Inspector's Report ABP-313742-22

Whether the works for improvement/refurbishment of existing chalet, the maintenance and renewal of the existing access for parking and servicing of existing chalet, the formation of new boundary and reconnection and maintenance of existing water supply, wastewater connection and electrical services is or is not development or is or is not exempted development.

Barrymore Townland, Hodson Bay, Athlone, Co Roscommon.

Client: EDVINAS CINGA
Drawing Title: Alignment drawing
Drawing Identifier: 21.17.MMA-A-205

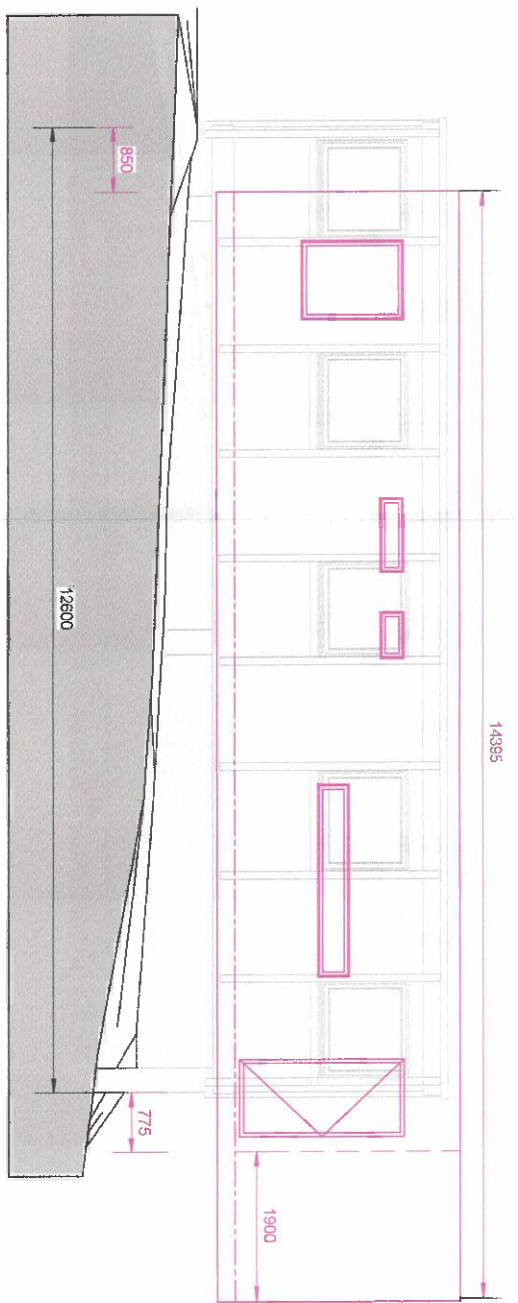
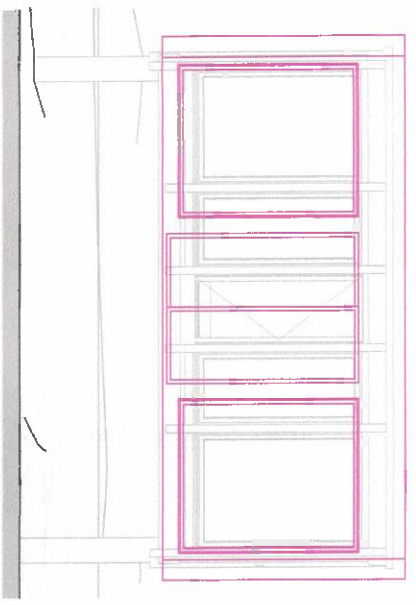
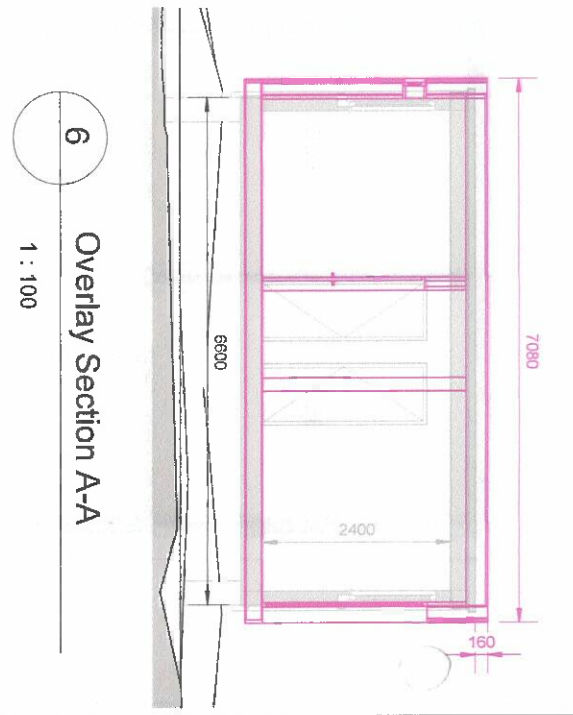
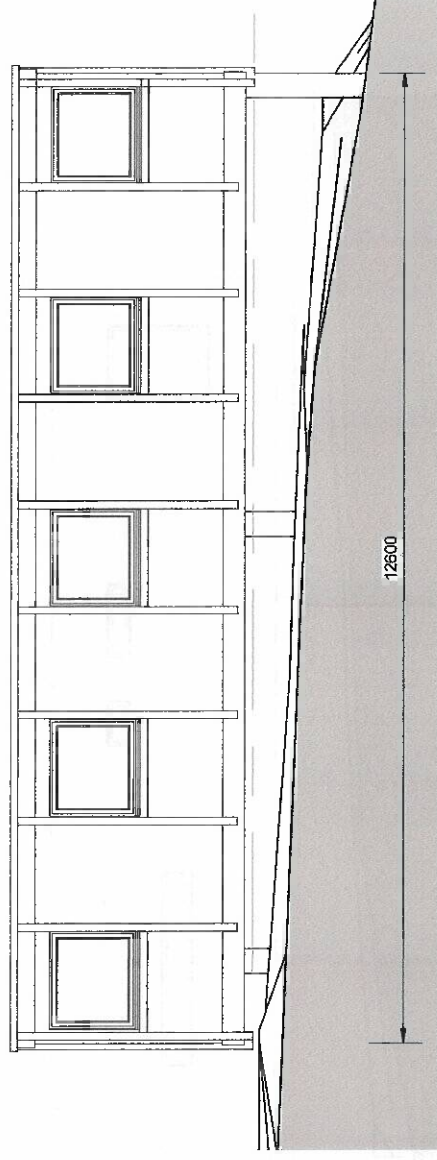
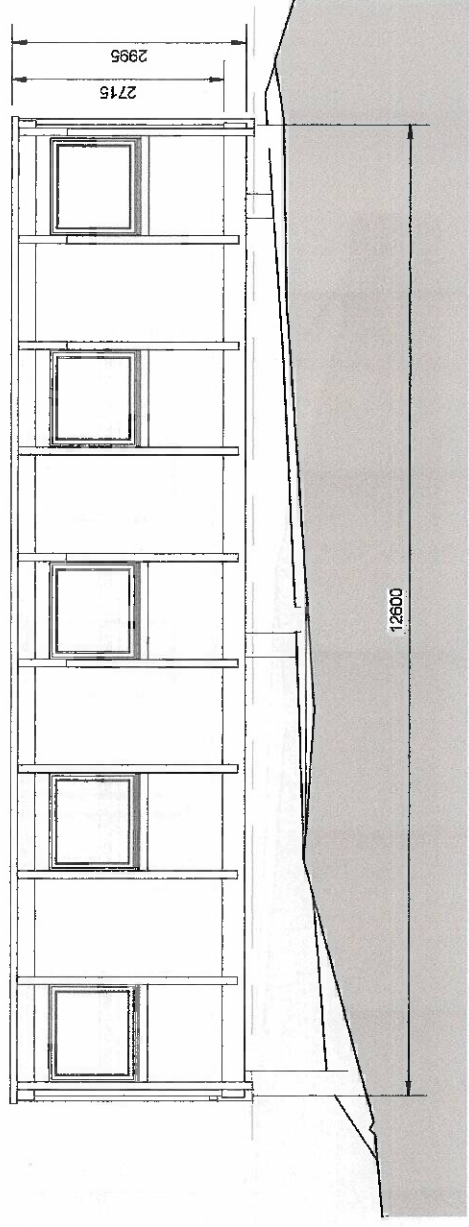
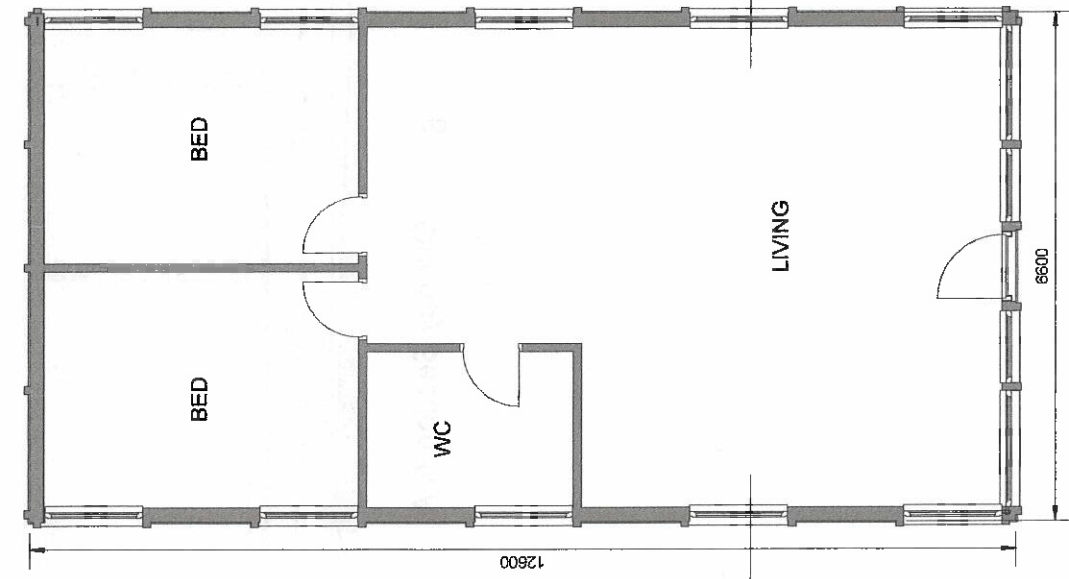
9.3.2. Alterations to the chalet are depicted on elevation and floor plan drawing No. 205. It can be seen from this drawing that the structure has been increased in width by 480mm, reduced in length by 75mm and increased in height by 160mm. Additional and revised window/door openings are incorporated across all elevations and its external appearance has been altered by the incorporation of vertical timber cladding.

9.3.6. Having considered the drawings provided with the application and also the photographic records of the chalet in both its previously existing and refurbished states, it is my opinion that the refurbished structure is materially different to the previously existing structure on the site. Its dimensions have been altered, additional and revised openings are incorporated across all elevations and its external

appearance has been altered by the incorporation of vertical timber cladding. In view of the foregoing, I do not consider the provisions of S4(1)(h) apply as the 'structure' is materially different in its size and appearance to the structure that was previously on the site.

9.3.8. In view of my assessment, I conclude that the carrying out of works for the improvement/refurbishment of the existing chalet is not exempted development.
